Re: Amended Plans – State Significant Development Application SSD-55844212

Property: 39 Dehli Road, North Ryde (Lot 21 / DP 1003588)

I refer to the above-mentioned State Significant Development Application – Trinit Lighthouse Build-to-Rent exhibited on 28 September 2023 for:

Figure 4 *Revisions to the public domain*

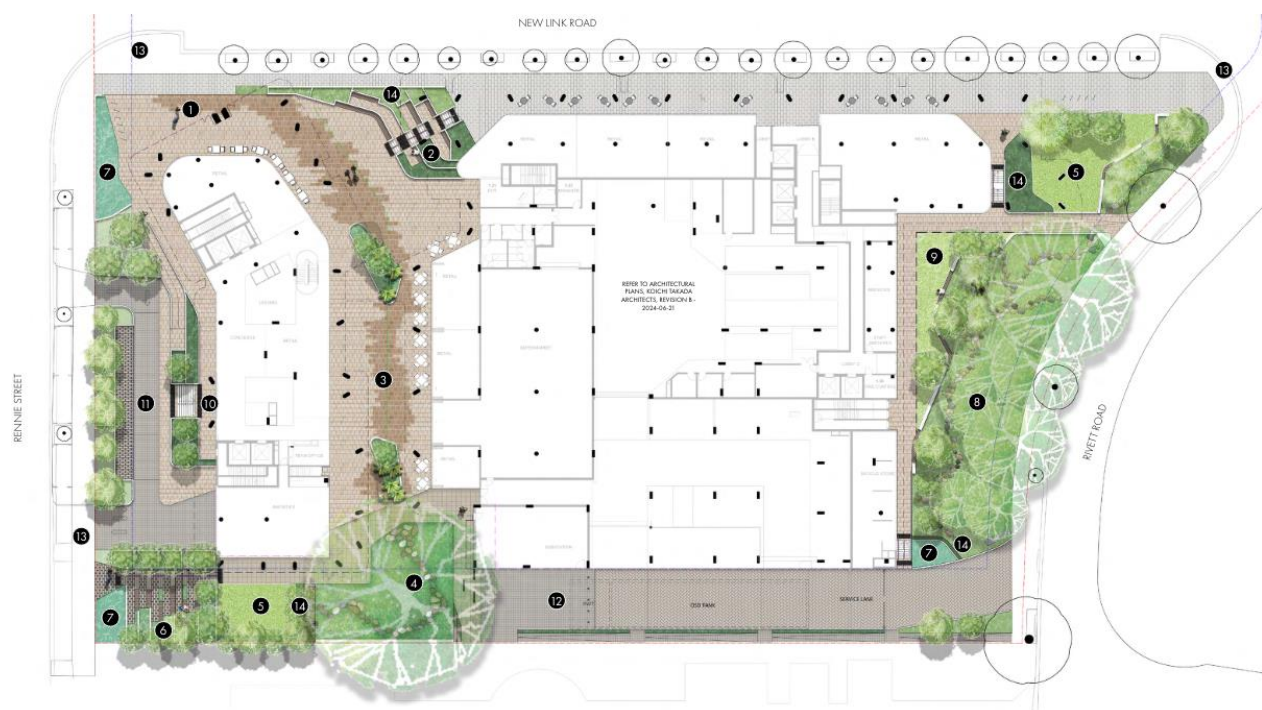
- The amended development has not provided adequate recreation areas or contributed to the access network within the precinct beyond that of the original proposal. The additional landscaped area at the eastern corner of the site does not contribute substantial additional deep soil landscaping beyond that of the original proposal as depicted in the plan extract below, and does not offer any meaningful recreational uses for the future residents of the development or broader public within the precinct to achieve Clause 6.9(3)(b) of the LEP

Further, the amended development provides only a negligible widening of the previously proposed pedestrian through-site link which serves only as a 'shopping arcade' for the ground floor retail spaces of the development and does not serve a recreational purpose. The proposed 'pedestrianisation' of New Link Road central to the site provides an under-sized children's playground and outdoor dining areas associated with retail – food and drink premises which are entirely inadequate for the amended development containing 510 x rental dwellings, noting as detailed previously, this road is proposed to be dedicated to Council as part of the Macquarie TOD Stage 2 rezoning therefore burdening public

- The applicant's response to submissions document provides that an additional 2,507m² of 'public domain' area is provided by the amended development. Given the proposed minor reduction in building footprint it is considered that the amended plans provide only a token increase to communal area through the inclusion of narrow and unusable parts of the site along the south-western boundary, and has included the proposed 'shopping plaza' central to the site.

Further, the public domain area has included part of the New Link Road to be dedicated to Council under the proposed Macquarie TOD Stage 2 rezoning of the precinct, thereby erroneously attributing a future potential roadway to the development's contribution to public recreation area.
